From: Simon Davis
Sent: 16 July 2018 11:43
To: 'Angus Eitel' [REDACTED]
Subject: RE: AW/71/18/HH

I've just looked again at the response this morning and have also just spoken with Mark. There is a part of the response that Mark gave that requires a couple of small changes to the reports which I need you to action and then send in the updated docs. The relevant text is as follows:

Drawing
Arboricultural Impact Assessment,
Arboricultural Method Statement

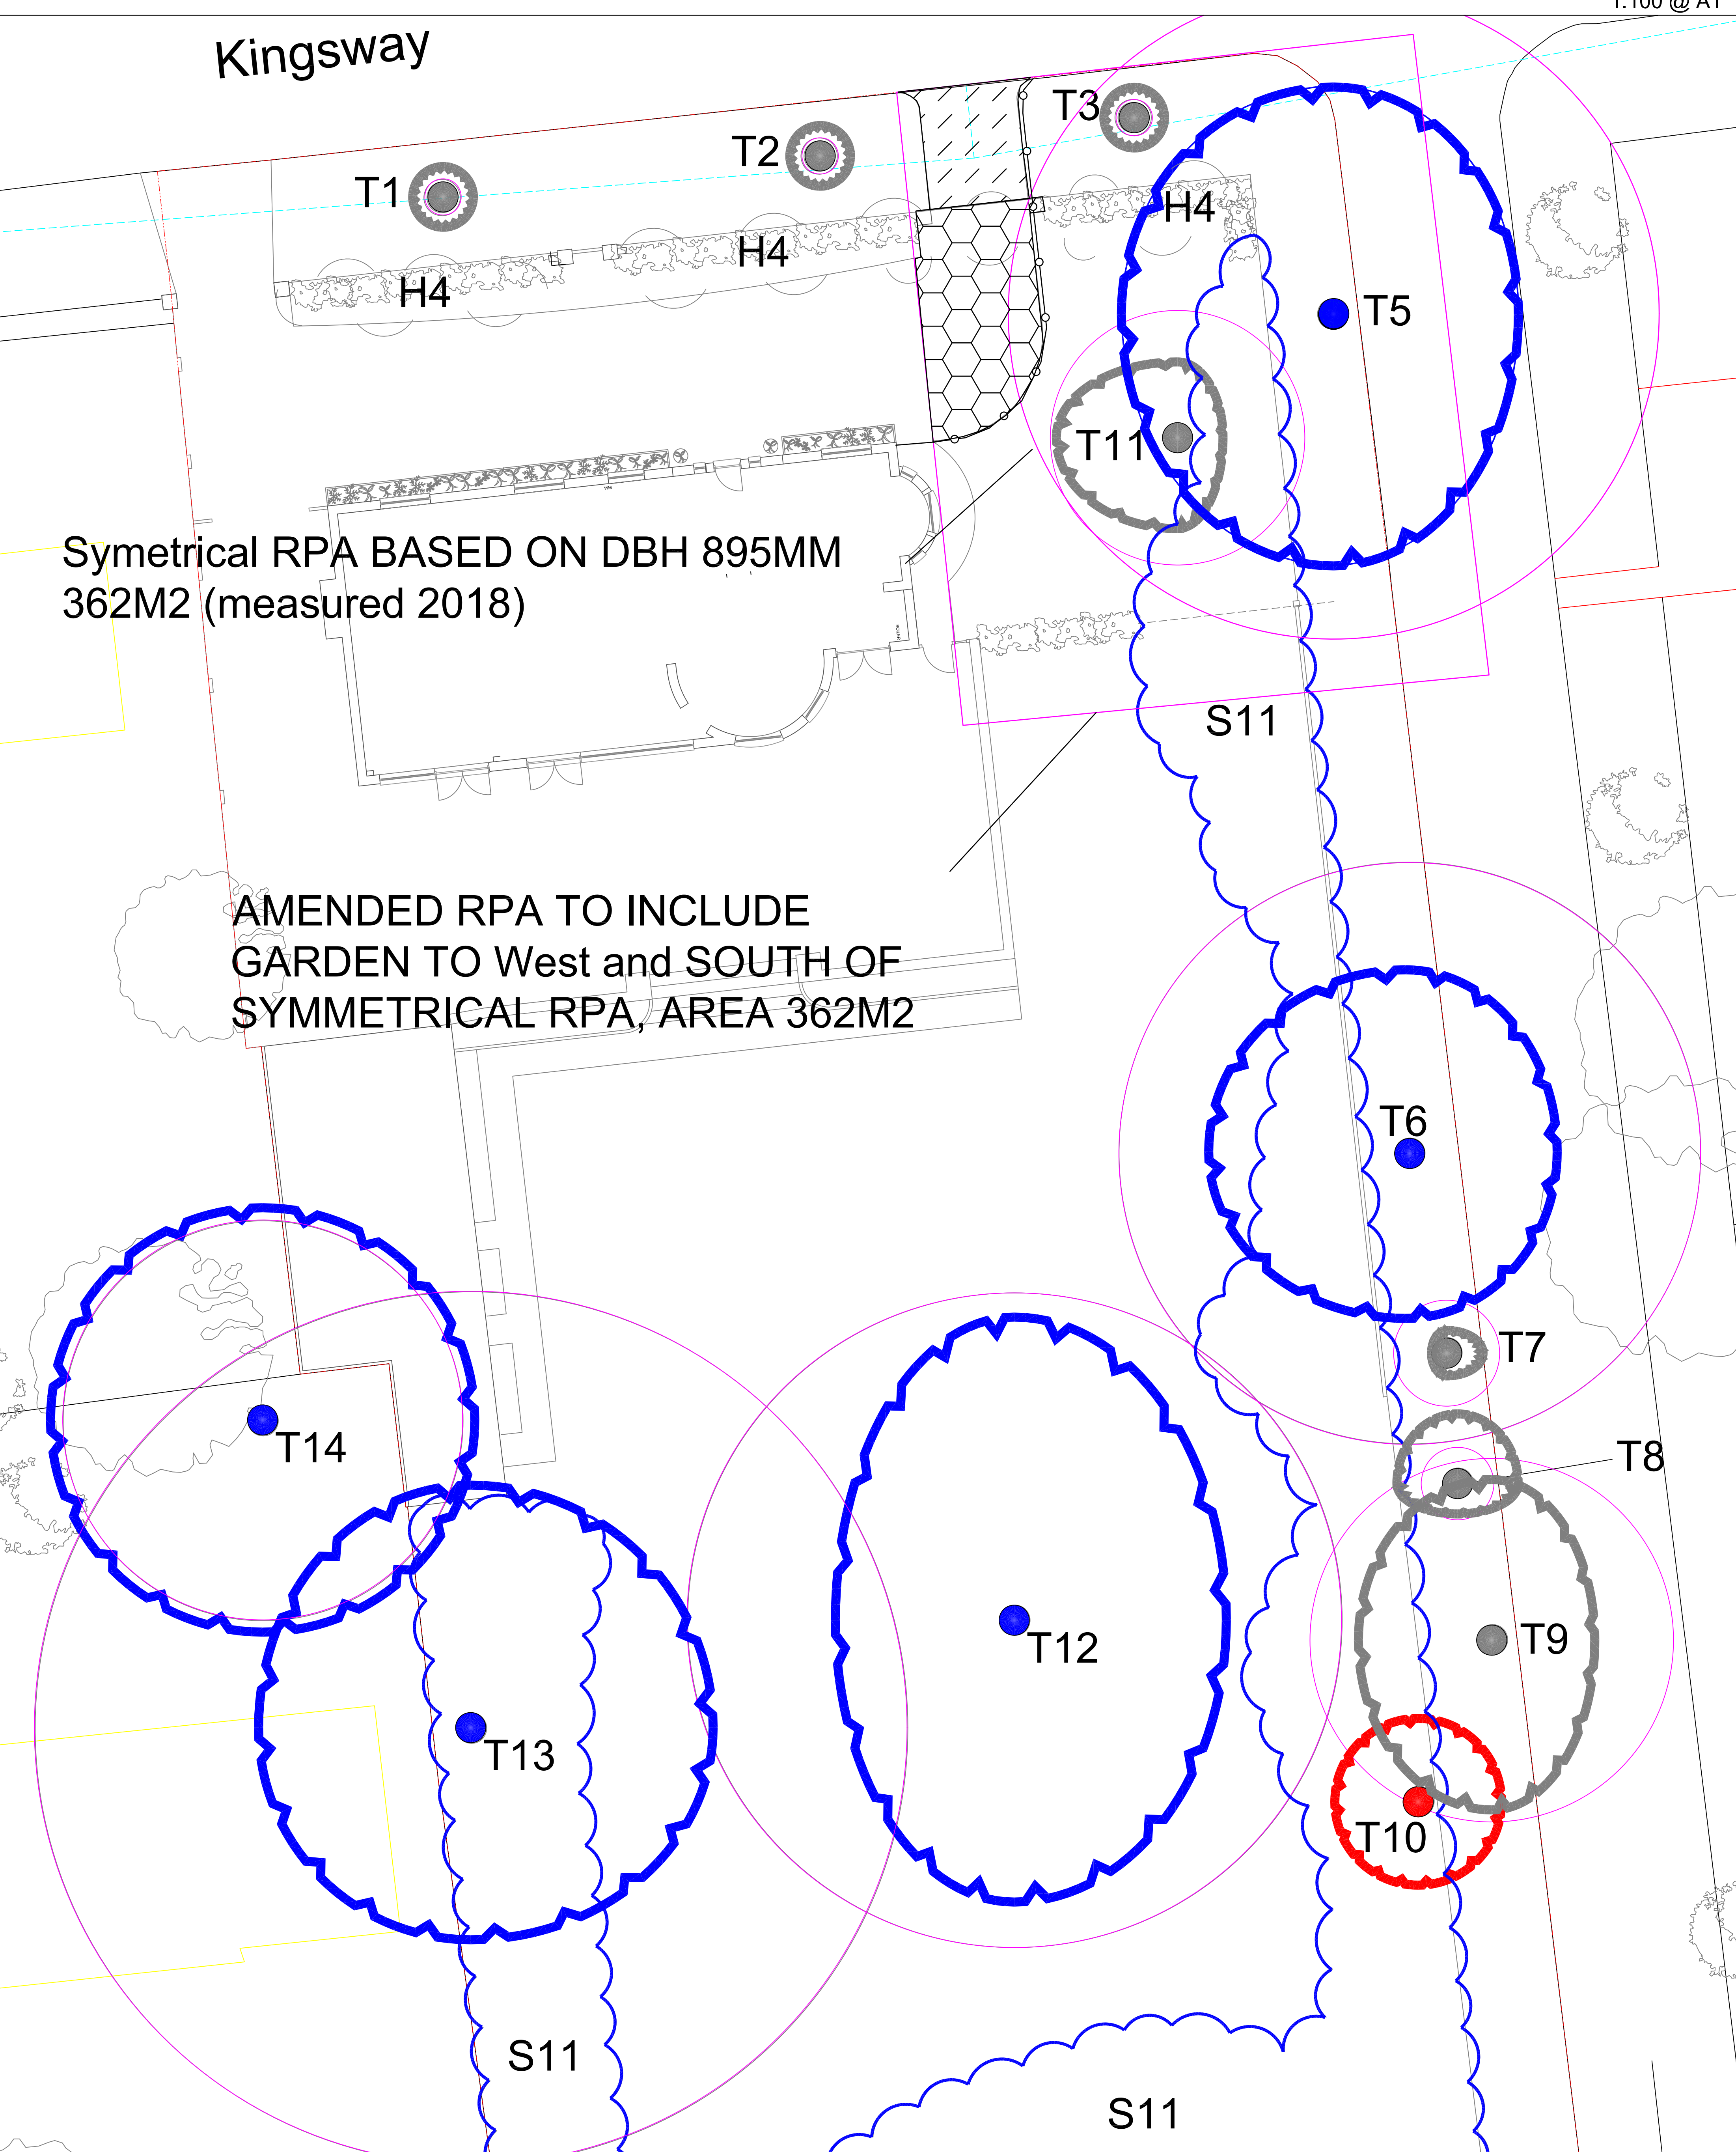
- I request confirmation that the area of 'No-dig' is undisturbed and adequately protected (it lies within the RPA) at the outset and immediately prior to installation of the cellweb construction layer. The ground protection measures necessary to achieve this should be determined by the project arboriculturist, with reference to the recommendations made in B55837:2012, section 6.2.3.

- Paragraph 8.1 of the AIA report should be amended so that it does not support the stripping of soil within the 'Nodig' area and explicitly states such practice is confined only to the verge outside the curtilage of the property.
